From: [REDACTED]
Sent: 20 June 2019 15:27
To: Sian Eggington
Subject: RE: Further Information Required on Your Ref: PP-07926902 Our Ref: AW/184/19/HH

Please find attached our further revised drawing 853 PL02 Rev B as requested.

DWG NO	853/PL02	REV.	B
---------------	----------	-------------	---

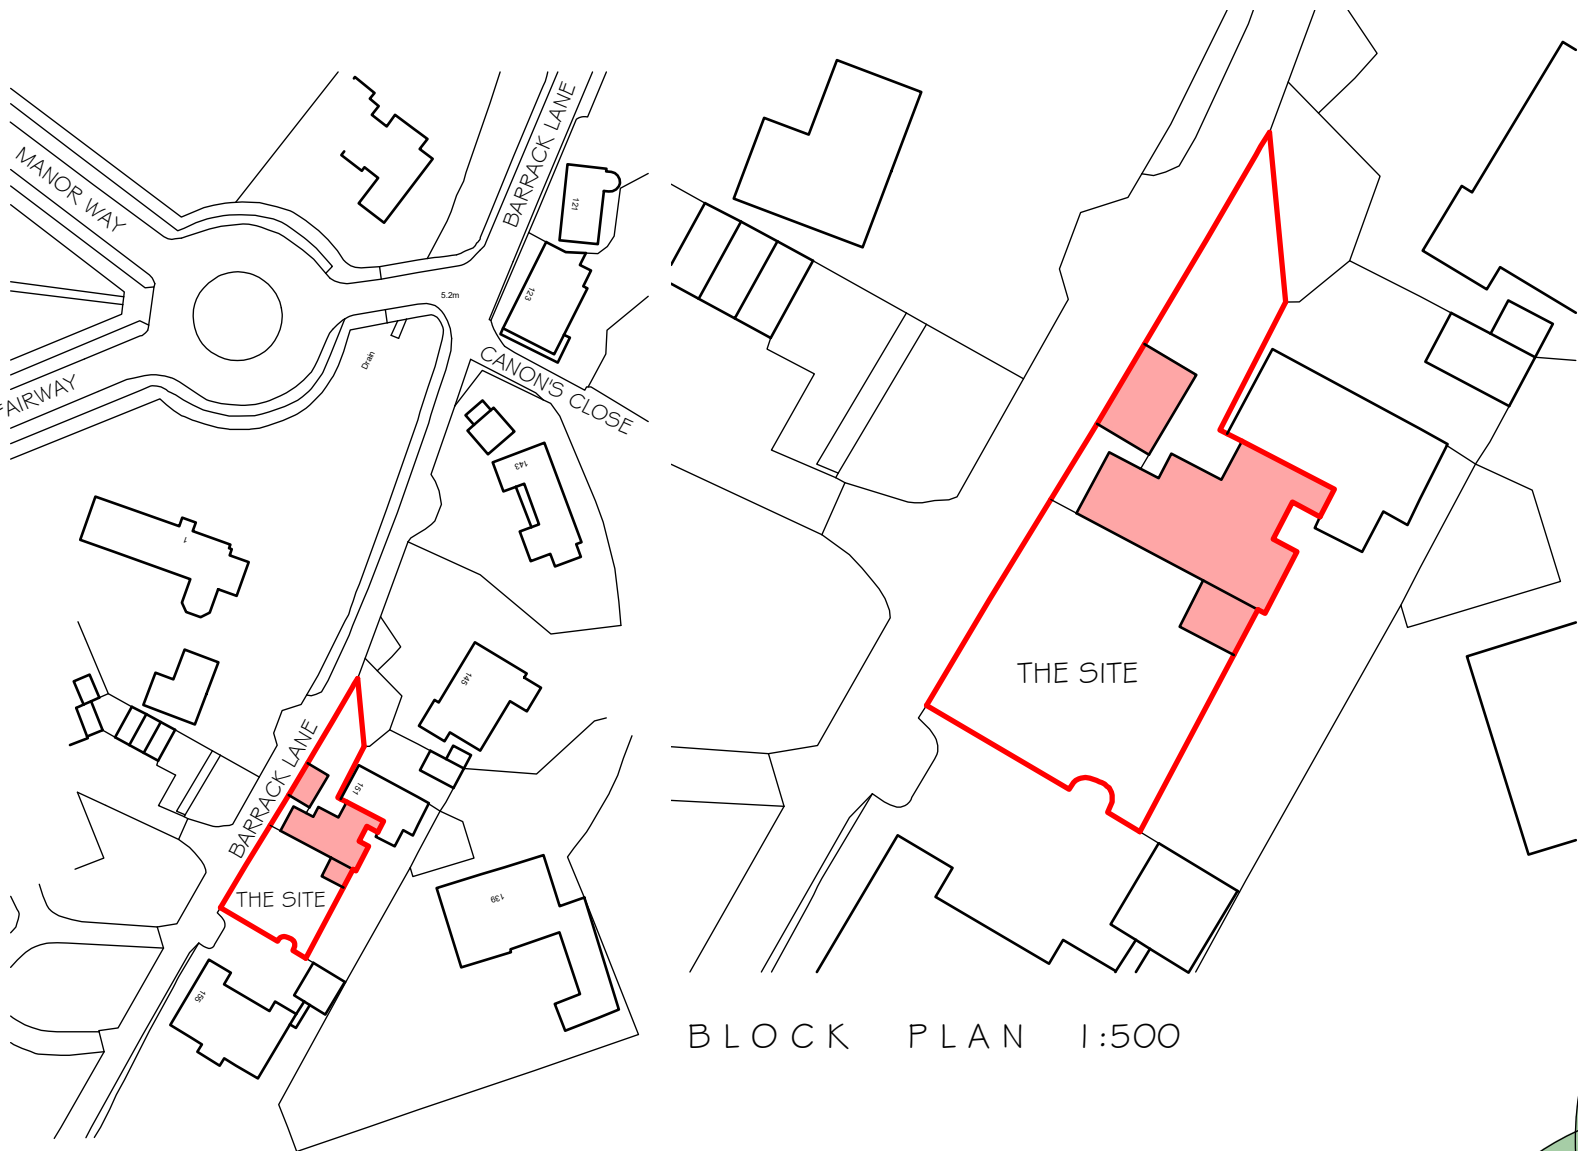
Thank you for your email. However a few further dimensions are required:

A dimension is required from the side extension to the rear boundary. Accordingly to my measurements it is around 17m from the side extension to the side boundary.

A dimension is also required from the proposed garden room to the front boundary this is measuring at around 12m.

Another from the garden room to the main dwelling measuring at around 8m. And finally one from the porch to the other side boundary is measuring in at 14m
